From: Michael Eastham
Sent: 18 April 2019 16:06
To: Planning.Responses
Subject: FW: Ashdown Vale Barnham - Retaining Walls - BN/59/18/DOC
Attachments: 17071 - 100 Rev G Engineering Layout.pdf

From: Laura Gibbons [REDACTED]
Sent: 16 April 2019 15:46
To: Nick Dyde
Subject: RE: Ashdown Vale Barnham - Retaining Walls

From: Nick Dyde [REDACTED]
Sent: 26 March 2019 12:21
To: Laura Gibbons
Cc: David J H Lee; Pete Hodgson
Subject: Ashdown Vale Barnham - Retaining Walls

Scale	1:500 @ A1	Drawn	TB
Date	May 2017	Checked	JB
File	17071/dwgs/civils/current	Drawing	17071 - 100 G

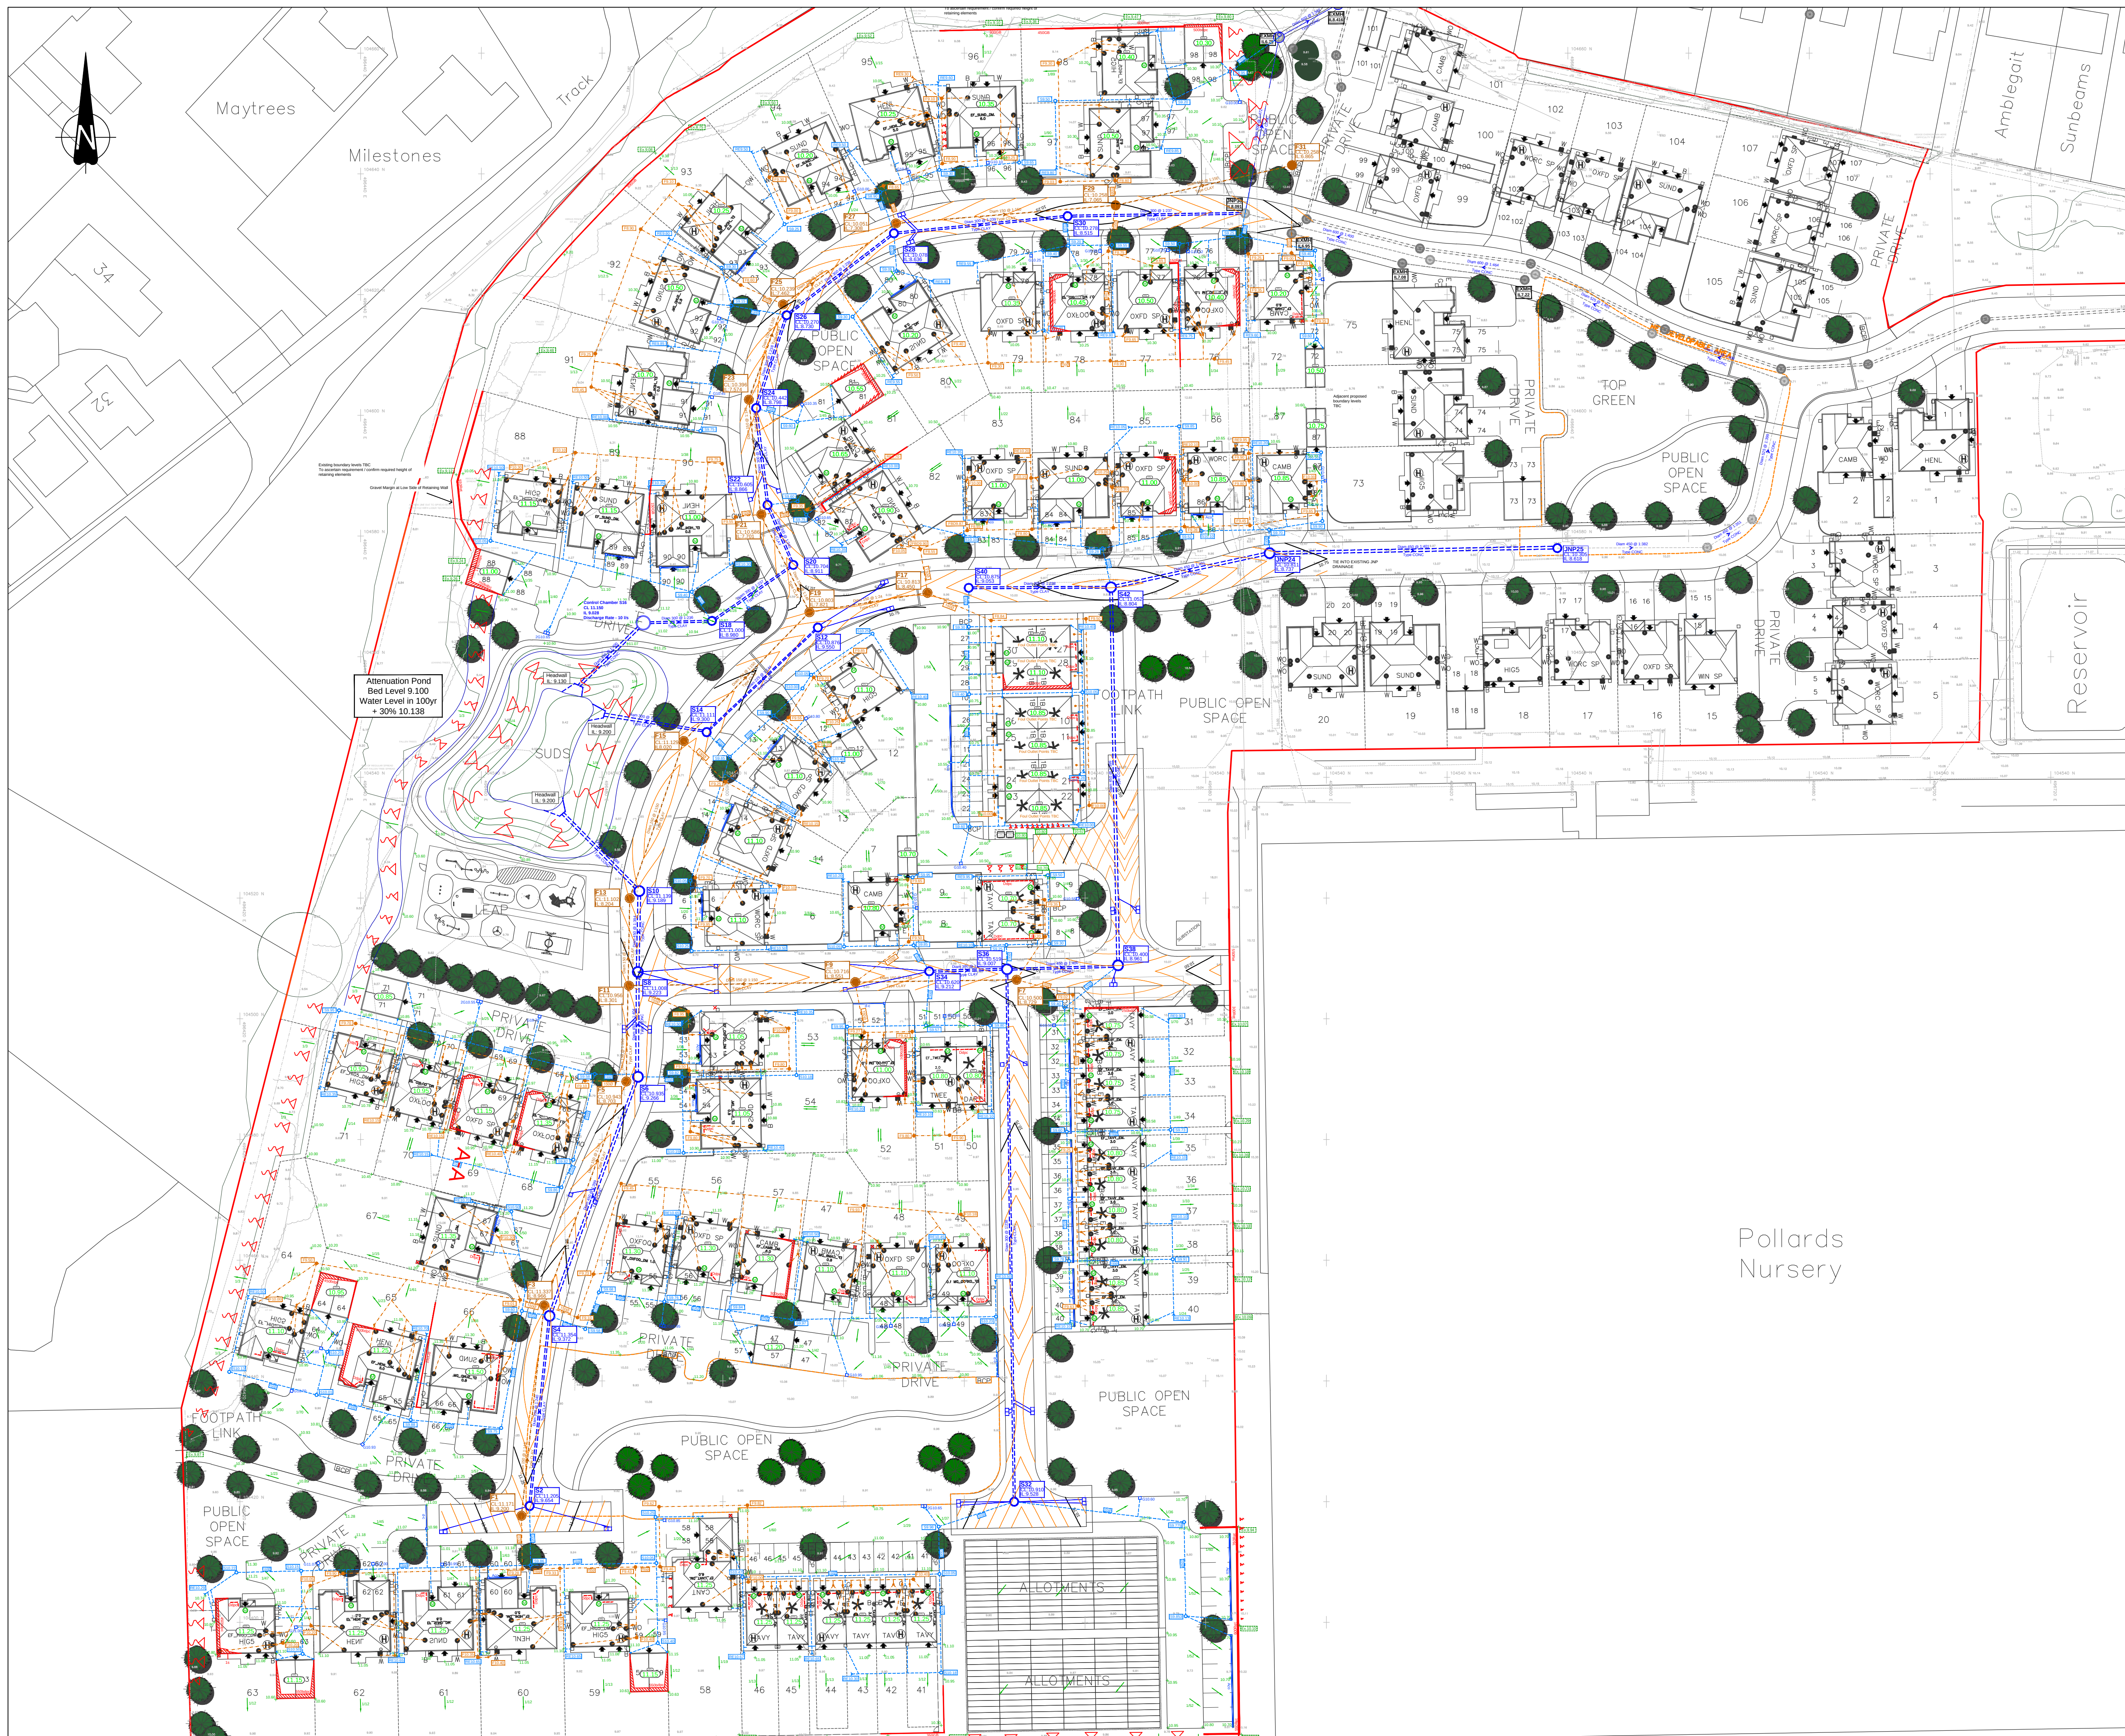
Construction details look okay. I await the updating of the layout to show the revised retaining wall locations and the surface water management statement.

I note the plan states that the slope of gardens at 92-93 has increased where the retaining walls are no longer required. I would like to see a gravel margin included where any revised slopes are effectively directing surface water runoff to neighbouring land.

The proposed wall at plot 88 will be okay with the proposed gravel margin.

Please send through revised construction detail drawings and layout.

Please find attached the latest Engineering Layout for Ashdown Vale to alleviate the drainage issues on the western boundary.

Ultimately it appears the majority of the walls along the western boundary can be designed out with the exception of plot 88. For this plot we propose to install a gravel margin on the low side of the wall to accommodate for flows discharging from the weepholes.
